Your Ref: OWPC24744
Our Ref: EP/124/19/PL 20-09-2019
Please ask for:
Mrs A Gardner

1 No. new detached single storey dwelling with associated access driveway & external works.

Rear of 16 Worthing Road East Preston

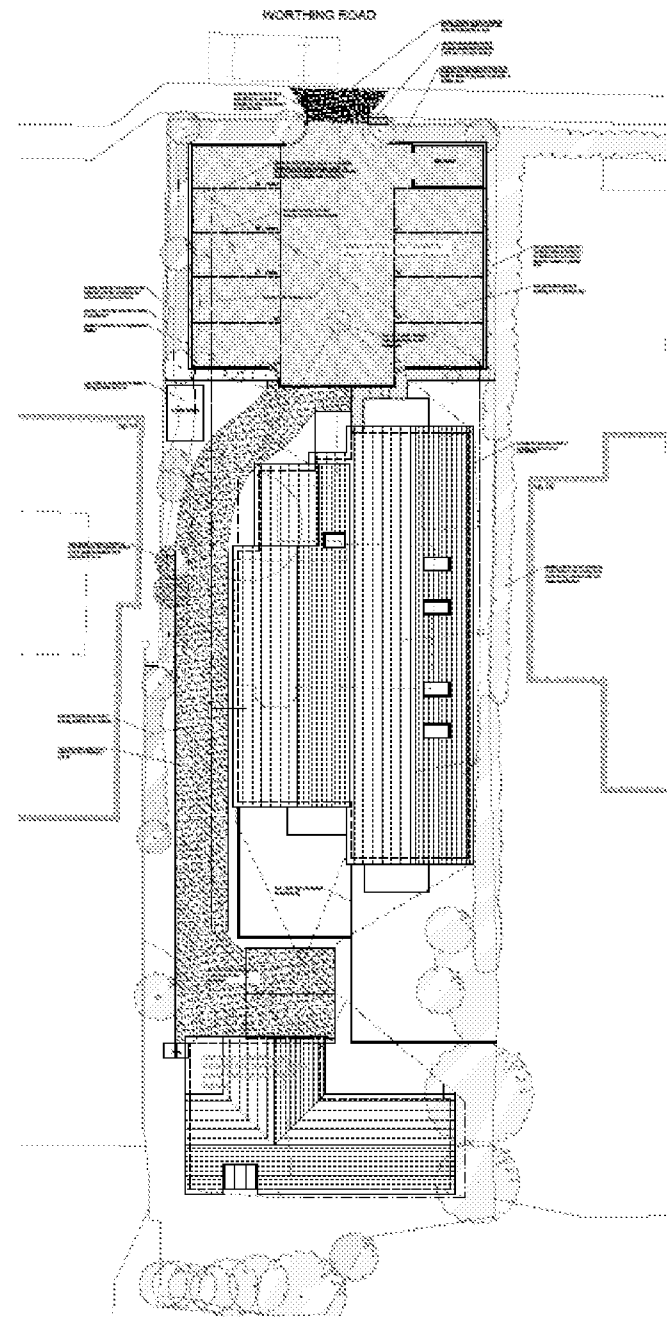
This proposal is to build a bungalow on what had been planned to be amenity land for the 6 flats for which planning permission has been granted. It would deprive the occupants of the flats of appropriate amenity space. Its position behind the flats fronting on Worthing Road would be out of character with other development along that road, and would place it close to the boundary of Langmeads Field, a designated open space.
